Comhairle Contae Chill Mhantáin Wicklow County Council

25th November 2024

RE: Appeal. ABP 321246-24 S5 Declaration Request, Ballymorris, Aughrim, Co. Wicklow

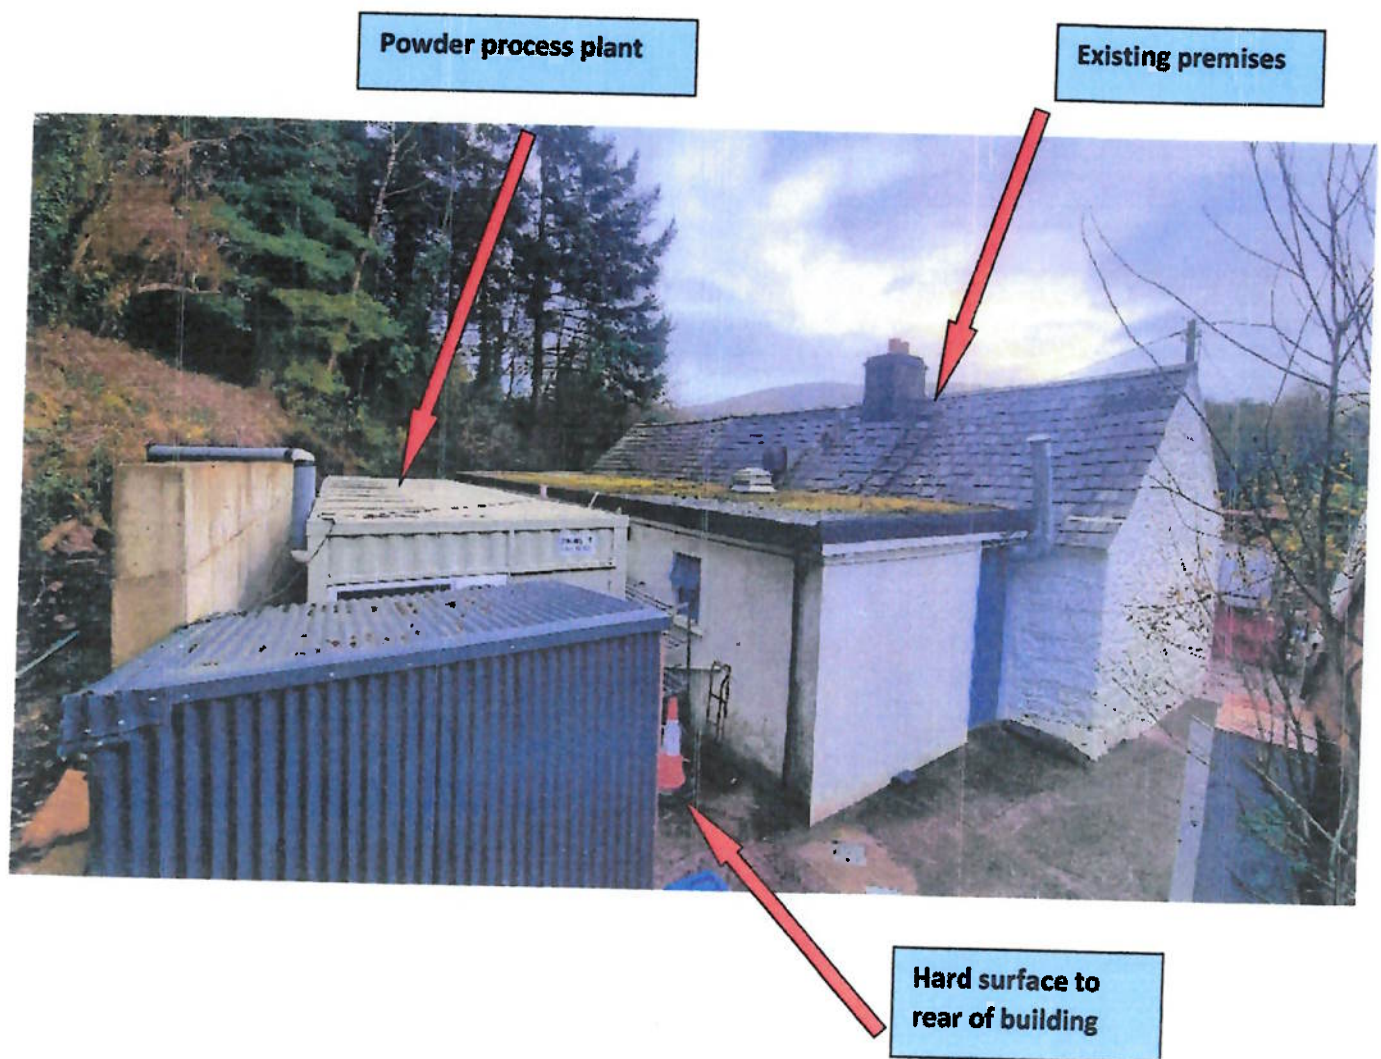
The submitted drawings show the construction of a ~3m high retaining wall and significant excavation to create the hard surface and to create the area onto which the “plant and machinery” was placed. Where the Board, consider that the “powder extraction plant” and “powder machinery” structure, is a structure of the nature of plant or machinery and therefore comes within the scope of Class 21 (a) (iii), the Planning Authority would consider that the significant retaining wall and excavation works to facilitate the “powder extraction plant” and “powder machinery” structure, would not be come within the scope of Class 21. Hence, the Planning Authority would consider that Class 21 (a) (iii) does not apply for the “powder extraction plant” and “powder machinery” structure.

Similar considerations to the above bullet point, apply to the provision of the hard surface. Hence, the Planning Authority would consider that Class 21 (b) does not apply for the provision of the hard surface.
